Subject: Response To Application Number BR/63/19/PL at 15-17 Kew GardensBognor RegisPO21 5RD

WEST SUSSEX COUNTY COUNCIL CONSULTATION

TO:	Arun District Council FAO: Stuart Corbey
FROM:	WSCC - Highways Authority
DATE:	12 April 2019
LOCATION:	15-17 Kew Gardens Bognor Regis PO21 5RD
SUBJECT:	BR/63/19/PL Demolition of existing building and erection of 6No. three bedroom dwellings with associated accesses and car parking.
DATE OF SITE VISIT:	
RECOMMENDATION:	Advice
S106 CONTRIBUTION TOTAL:	£ N/a

Project:-	Proposed Residential Development 15-17 Kew Gardens Bognor Regis West Sussex		
Title:-	Block Plan		
Client:-	Farnden Developments Ltd		
Scale:-	1:500 (@A3)		
Drawn By:-	PJD	Checked By:-	PJD
Date:-	14/02/19	Date:-	14/02/19
Job.No:-	180037	Drg.No:-	02
		Rev:-	A

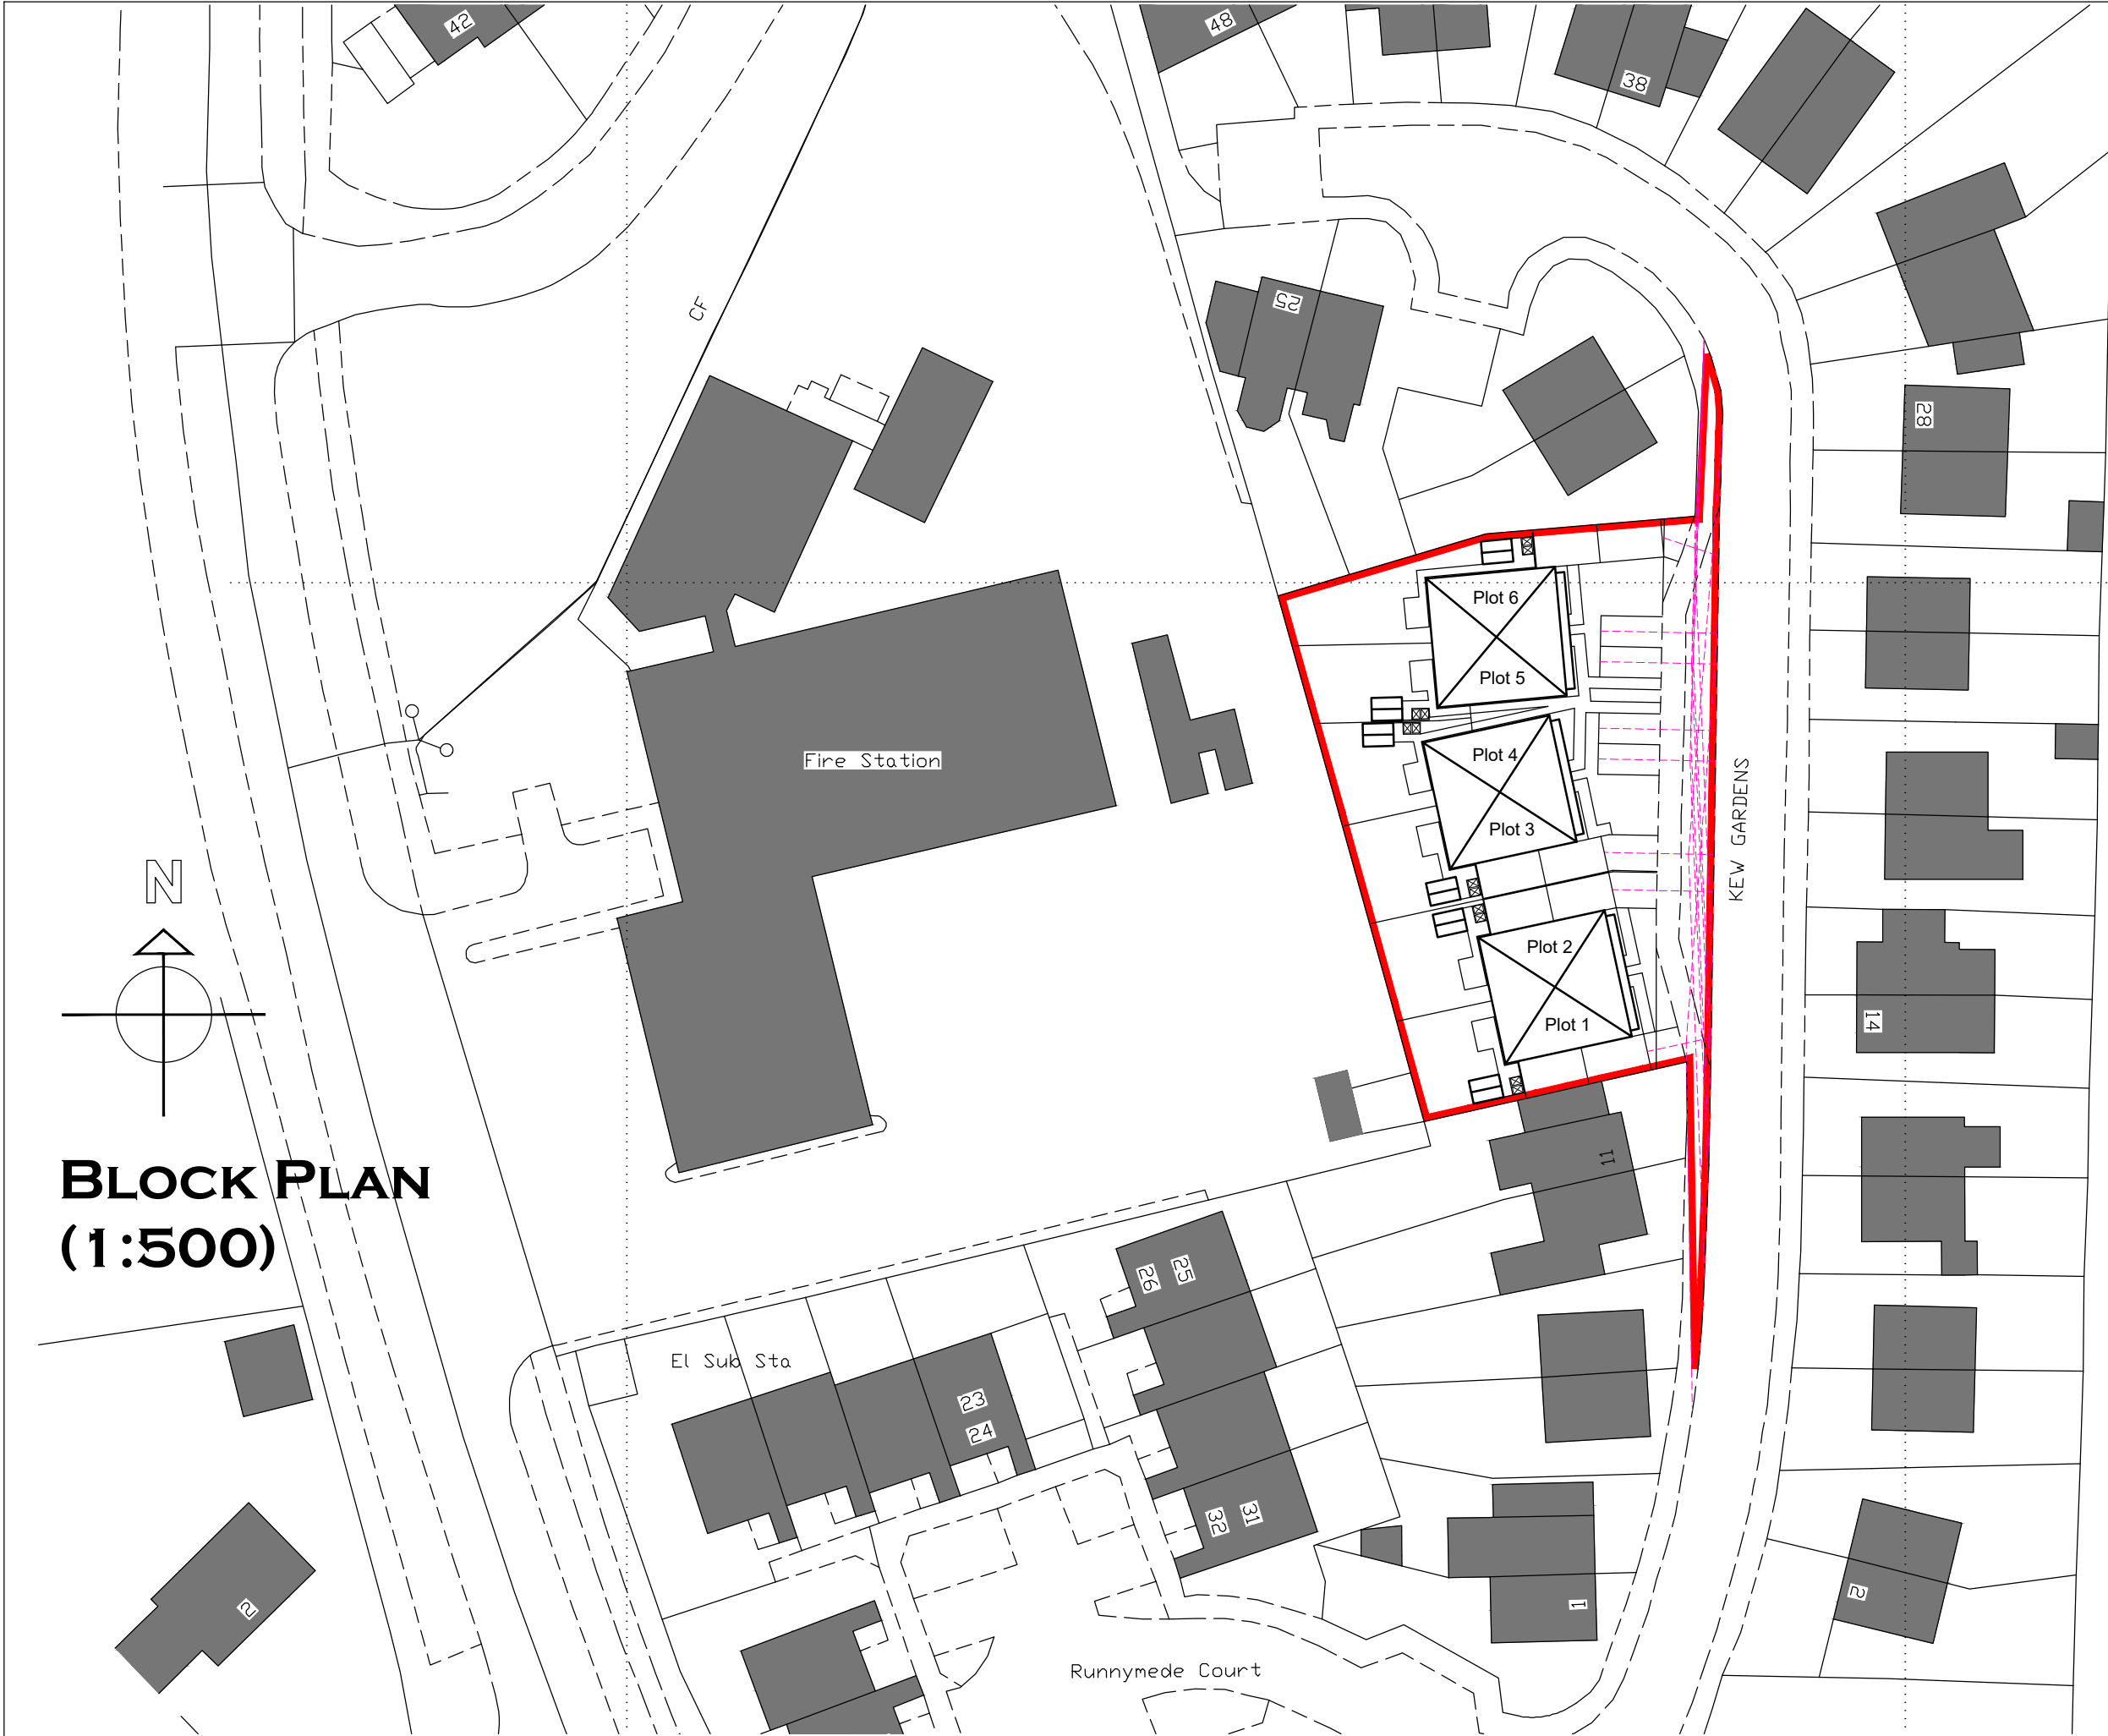
The visibility splays provided are difficult to read as the splay for each access overlaps with the neighbouring visibility splay. A clear revised plan should be provided prior to occupation, which shows the maximum achievable visibility splays from the access point. Due to the fact that Kew Gardens is a no-through road and speeds and vehicle movements are low, this would be anticipated to be sufficient for the use. These splays should be measured 2.4m back from the edge of the highway and span as far as possible to the highway edge on the same side of the road. The splays must intercept only land within the control of the applicant or the highway boundary, the property red edge does not need to include the extent of the visibility splays only the access points.

Similarly the pedestrian visibility splays have not been demonstrated, these are required to be shown 2m back into the site either side of the access and a distance measured along the back of the footway for 2m on each side of the viewpoint.

I acknowledge that the southern and northernmost accesses may not have space to accommodate the entire 2m x 2m splay due to the proximity with neighbouring properties; therefore it is advised that these are provided to best of ability within land under the control of the applicant.

No part of the development shall be first occupied until maximum visibility splays shall be provided at the site access onto Kew Gardens in accordance with a plan to be submitted to and approved by the planning authority. These splays shall thereafter be kept clear of all obstructions to visibility above a height of one metre above the adjoining road level.

No part of the development shall be first occupied until pedestrian visibility splays of 2 metres by 2 metres have been provided or to best of ability either side of the proposed site vehicular access onto Kew Gardens in accordance with plans and details to be submitted to and approved in writing by the Local Planning Authority. These visibility splays shall thereafter be kept free of all obstructions over a height of 0.6 metre above adjoining carriageway level or as otherwise agreed.
